Application No: FG/68/20/HH
Site Address: 9 East Onslow Close Ferring BN12 5RR
Description of works: New balustrade balcony to existing flat roof extension.

OWPC28565

PROPOSED BALCONY BALUSTRADE ELEVATIONS
AT 9 EAST ONSLOW CLOSE
FERRING
WEST SUSSEX BN12 5RR

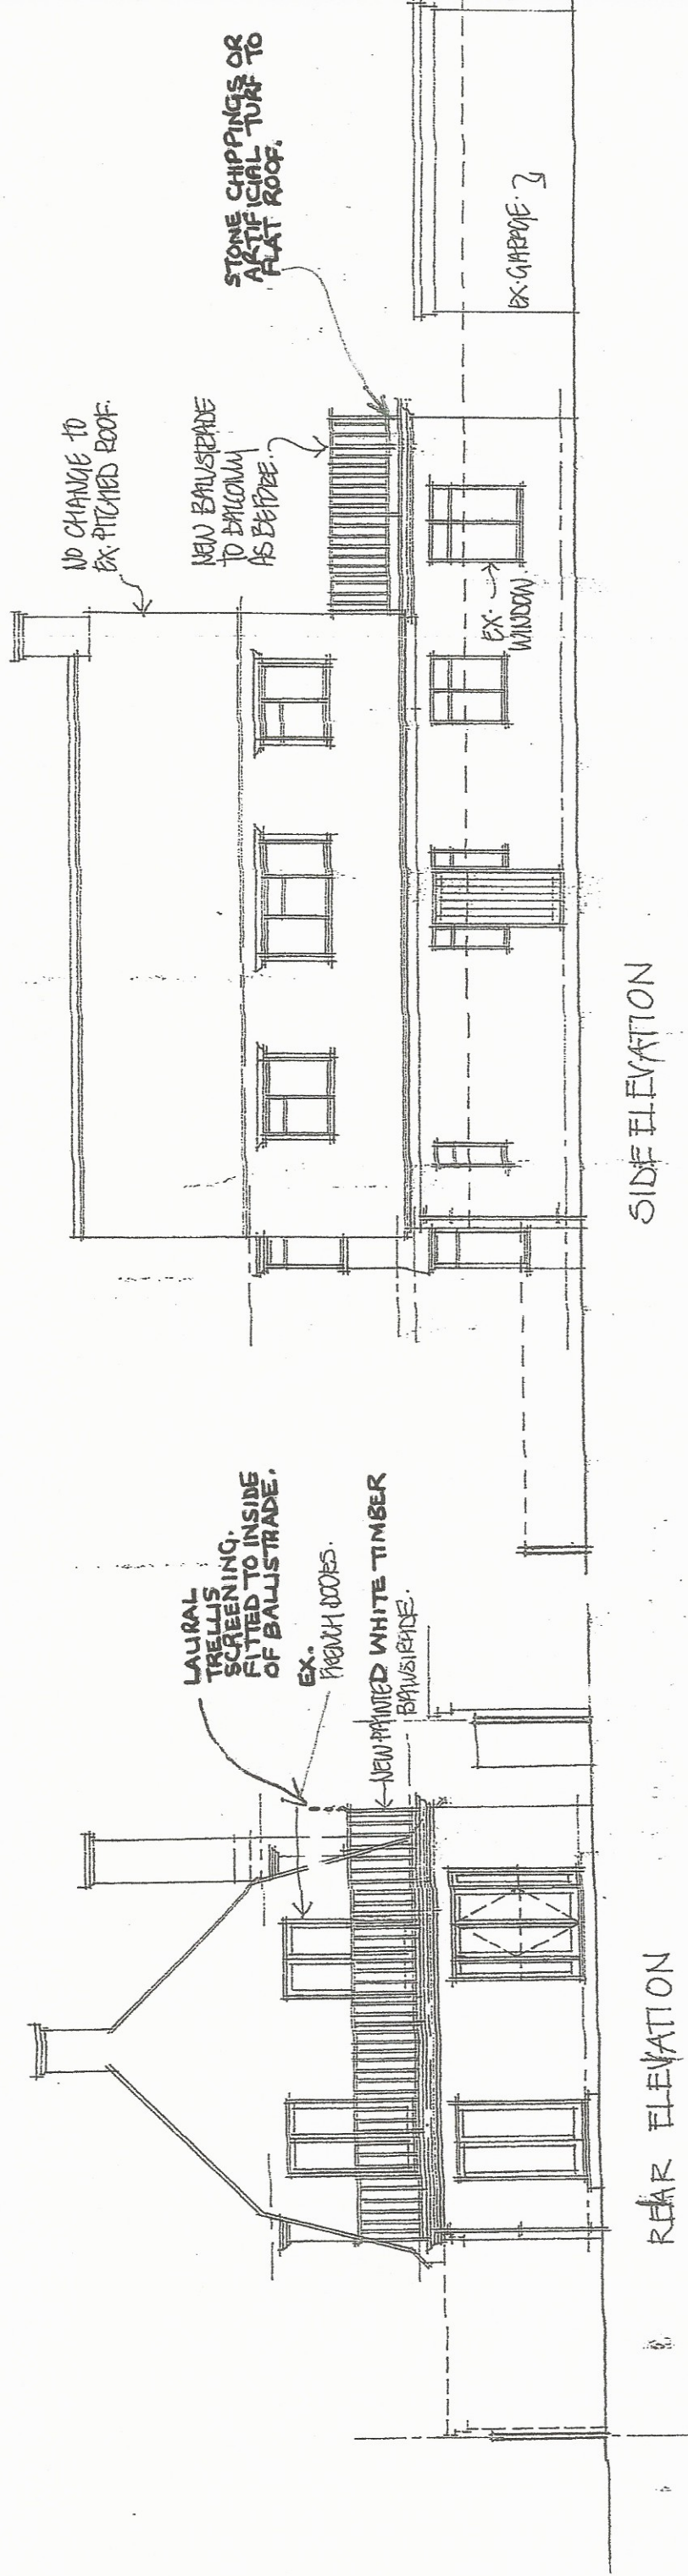
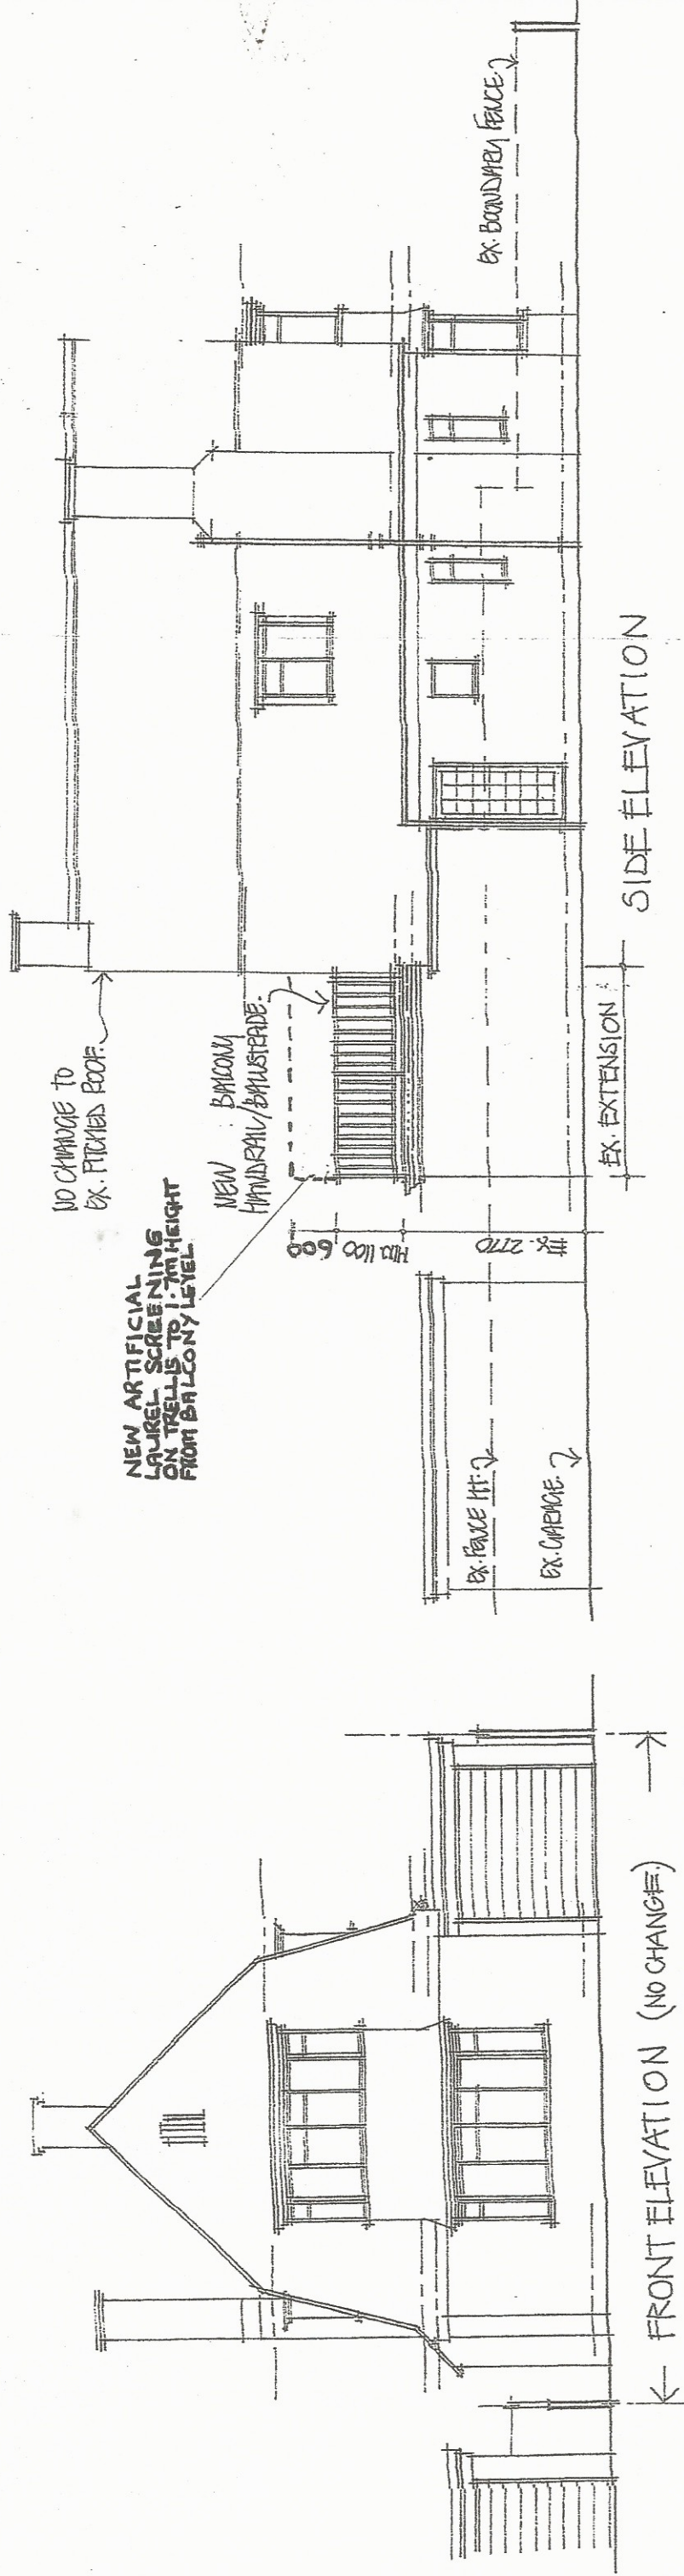
While Ferring Parish Council raised no objection to the previous application, this retrospective application to create a large first floor external platform raises concerns in respect of the additional overlooking implications.

The impact of being able to stand at this elevated level with unhindered line of sight to both side elevations and the rear elevation is a significant change to the overlooking potential on adjacent properties. We seek assurance from ADC Planning that a full assessment is made of the impact on the privacy of neighbouring properties and gardens prior to any decision being reached, should they be minded to approve this application.
